CITY OF ALBUQUERQUE

March 6, 2026

**RE: 4525 Quaker Heights PI NW
Grading and Drainage Plan
Engineer's Stamp Date: 02/26/26
Hydrology File: F11D020B
Case # HYDR-2026-00073**

GD1

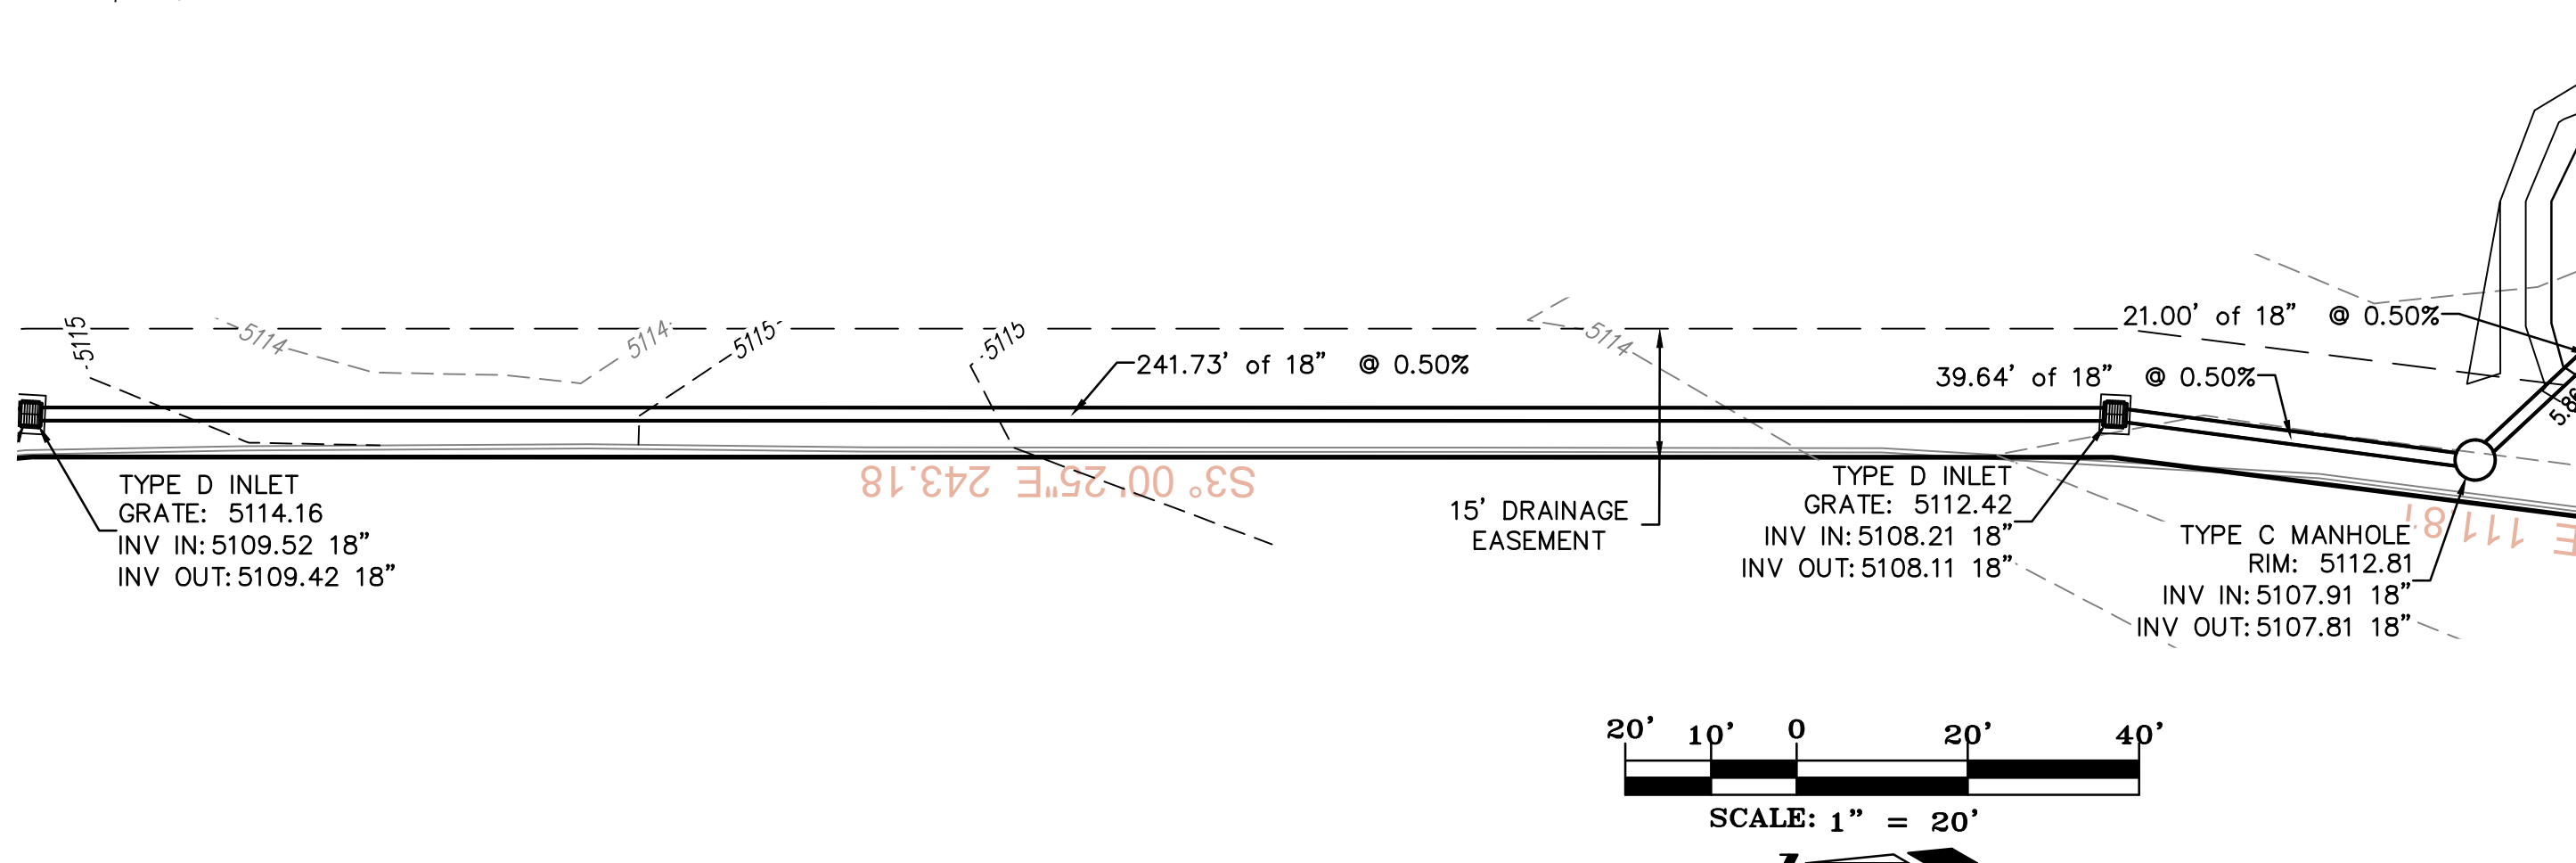
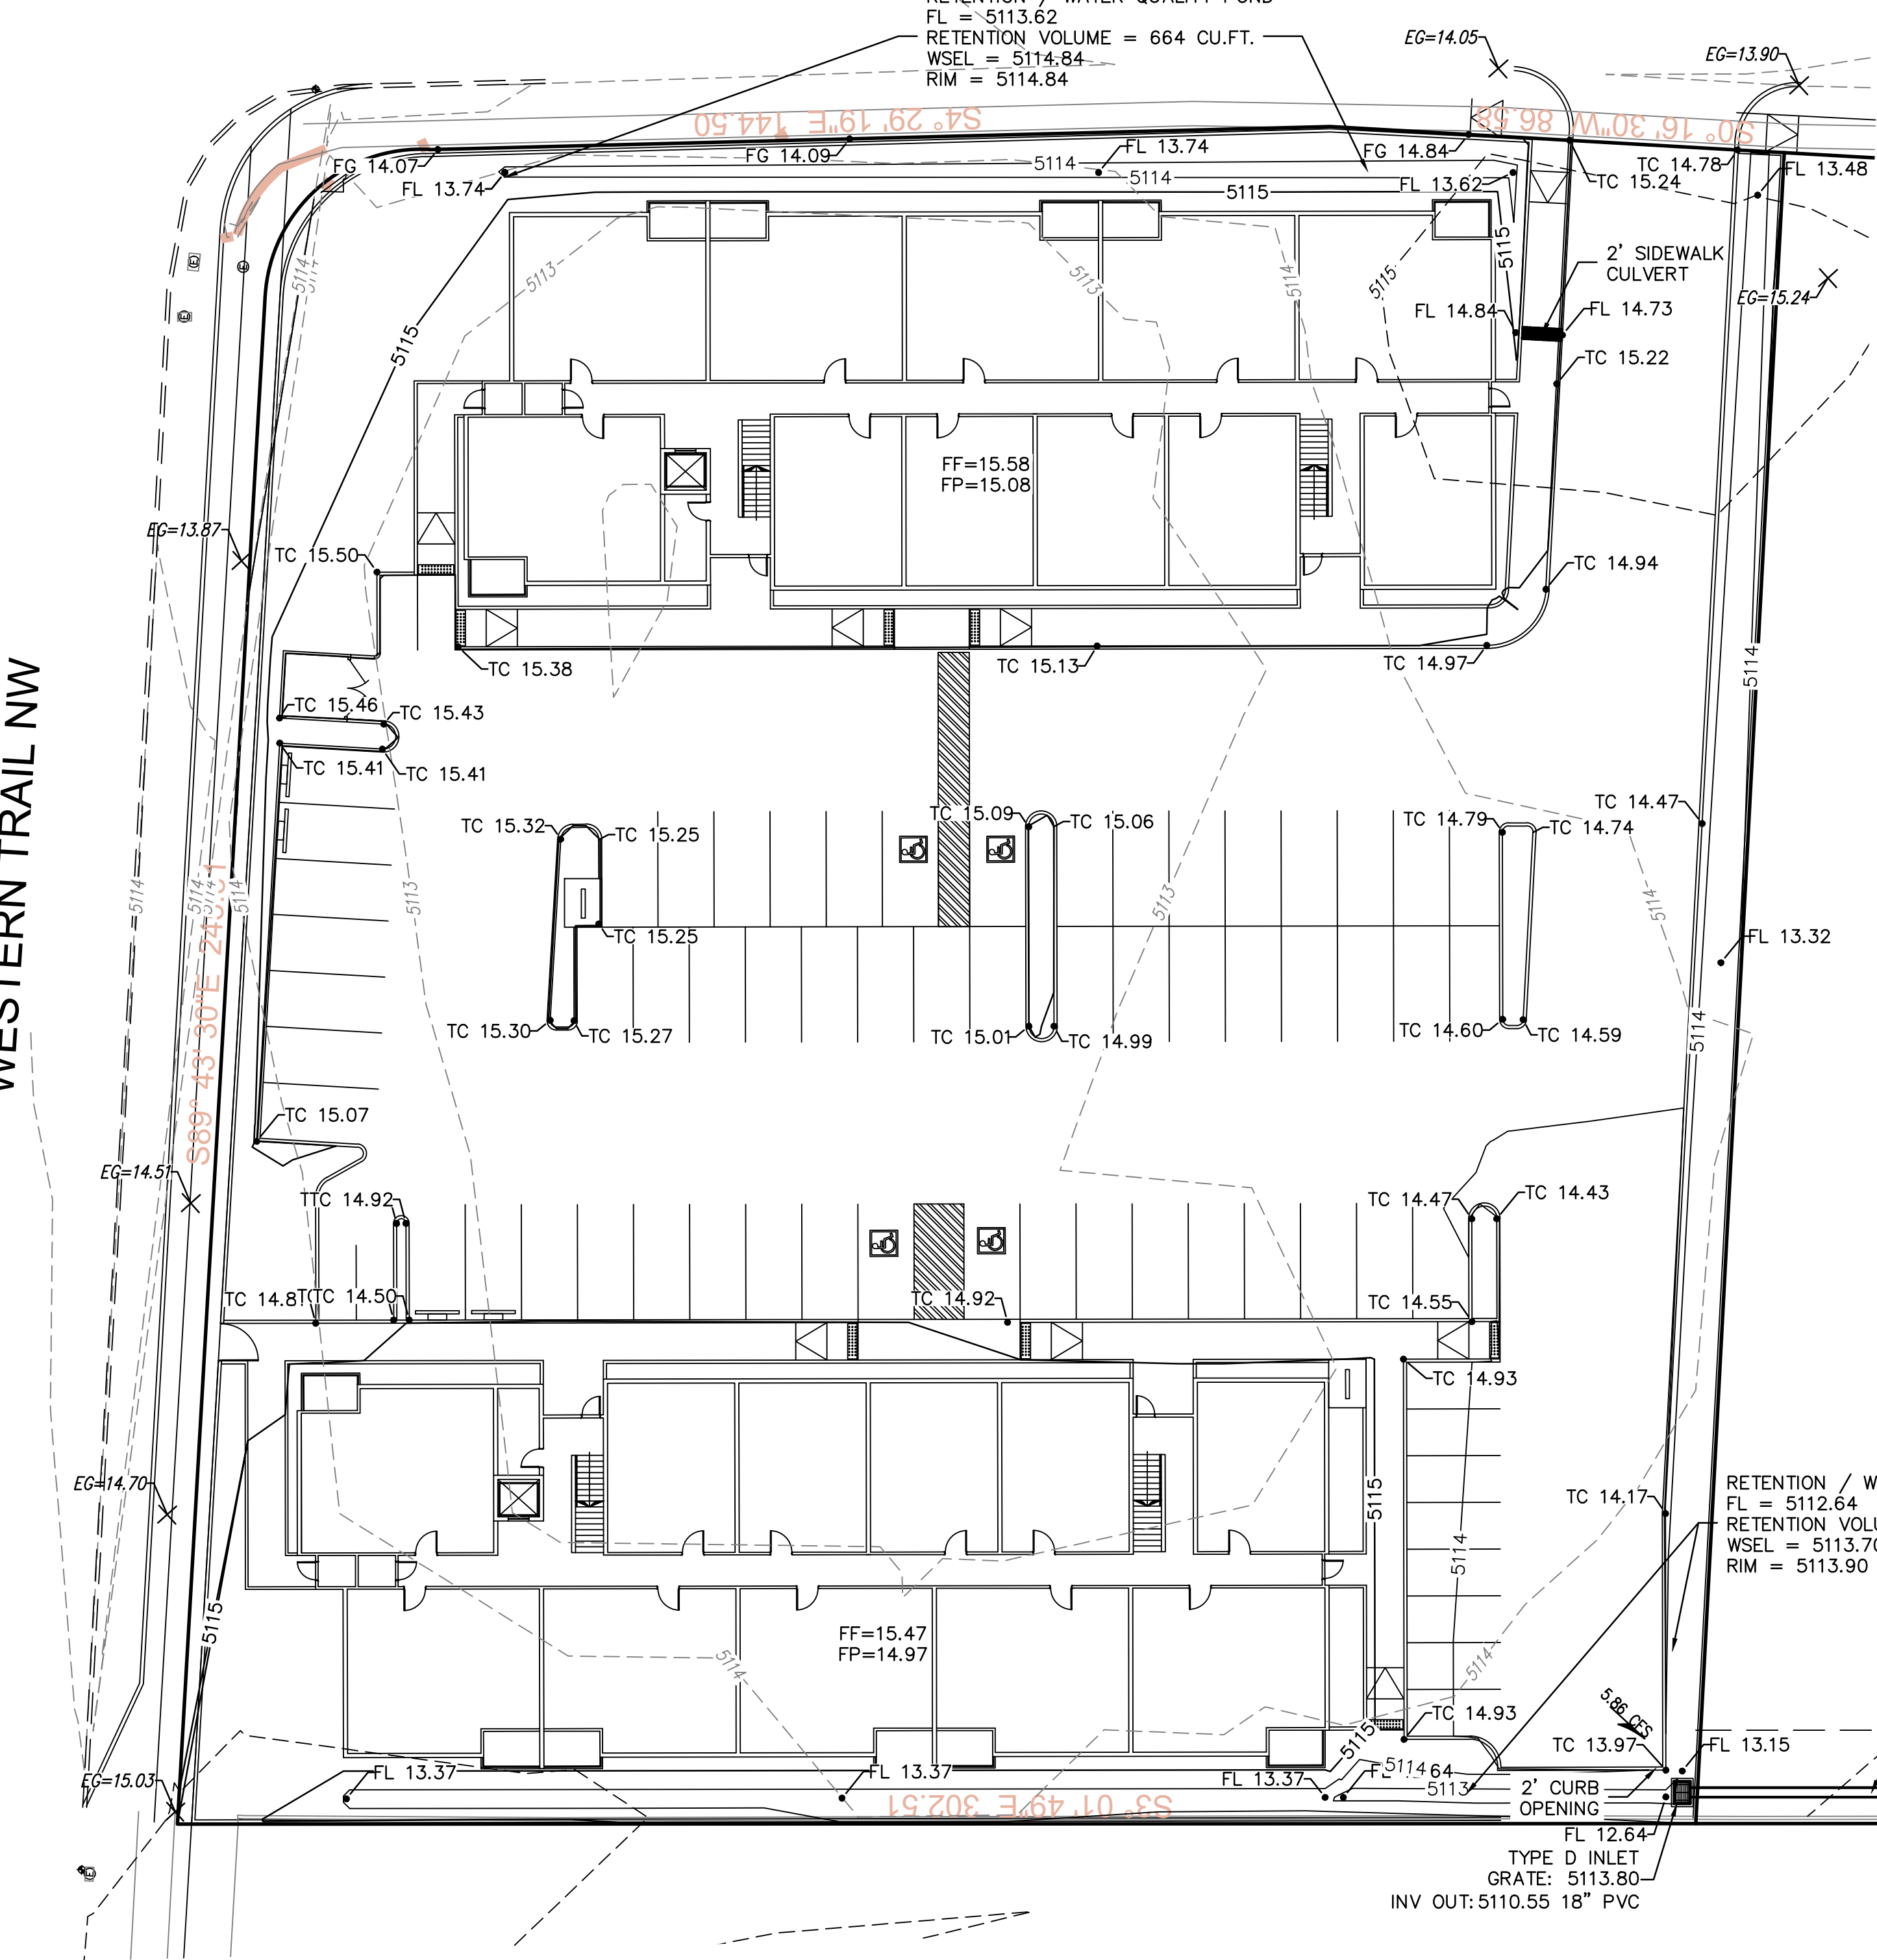
1. Please provide the FIRM Map floodplain note with effective date.
2. Please provide the legal description of the property.
3. Please show Finished Pad Elevations in addition to Finished Floor Elevations for all structures.

4. Payment in Lieu (Amount = $599\text{CF} \times \$8/\text{CF} = \$4,792$, per sheet GD1) of onsite management of the SWQV must be made. Fill out and submit for approval the Application for Payment-In-Lieu to Hydrology. When approved and paid, take three copies of the treasury deposit slip to the Treasury and then include one copy of the paid deposit slip when resubmitting.
5. Please add a note which states, "The Owner has elected to pay the Payment in Lieu for the required Stormwater Quality Volume."
